Our Ref: 23/04519/HFUL  
Your Ref: 41a Glover St Carport

**South Cambridgeshire District Council**  
**Application for Planning Permission**

Proposal: I would like to build a single carport at the front of my plot on the right hand side. The carport would be attached to my outbuilding on the one side and be supported by timber posts on the other.

Site address: 41A Glover Street Over Cambridgeshire CB24 5PQ

Drawing
SITE LOCATION & BLOCK PLAN

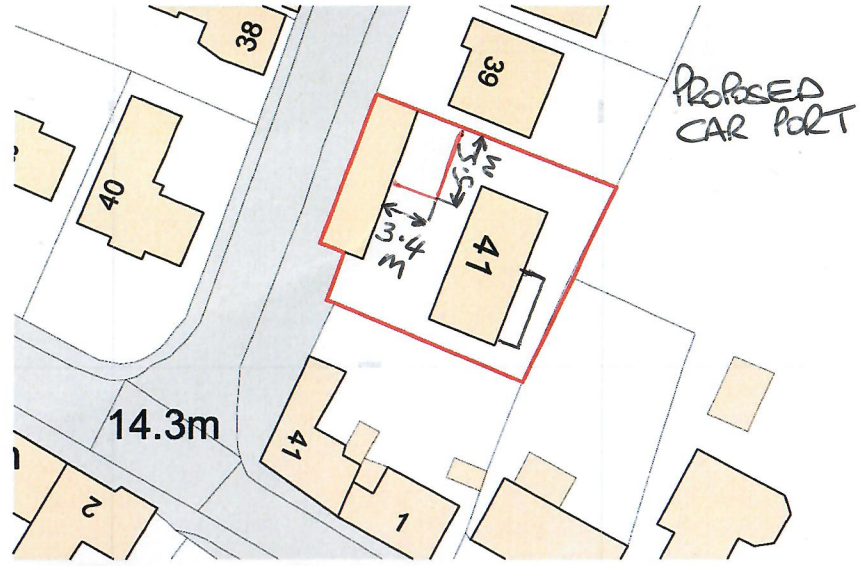
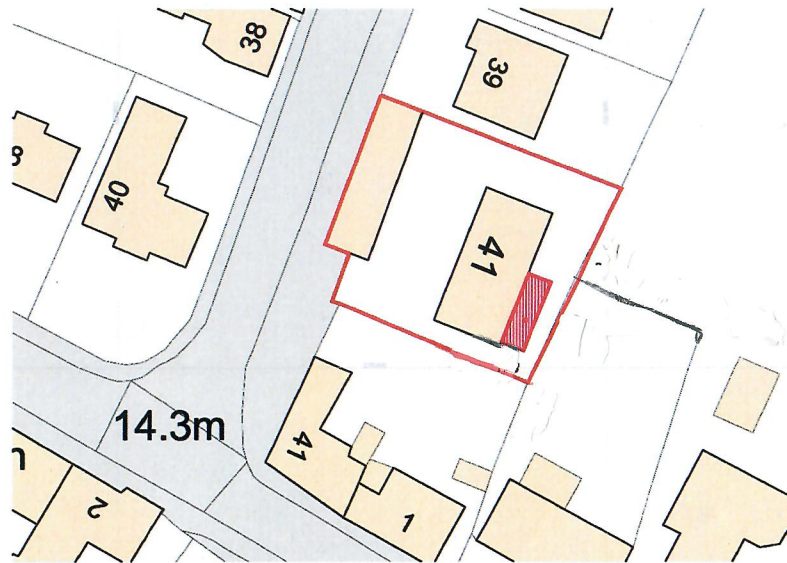
1. Please state which location plan you would like us to use. You have submitted two that have different red site boundary lines.
2. Please confirm if 41a Glover Street is a residential dwelling?
3. The street maps in your plans state 41 Glover Street not 41a. Please provide plans for 41a.
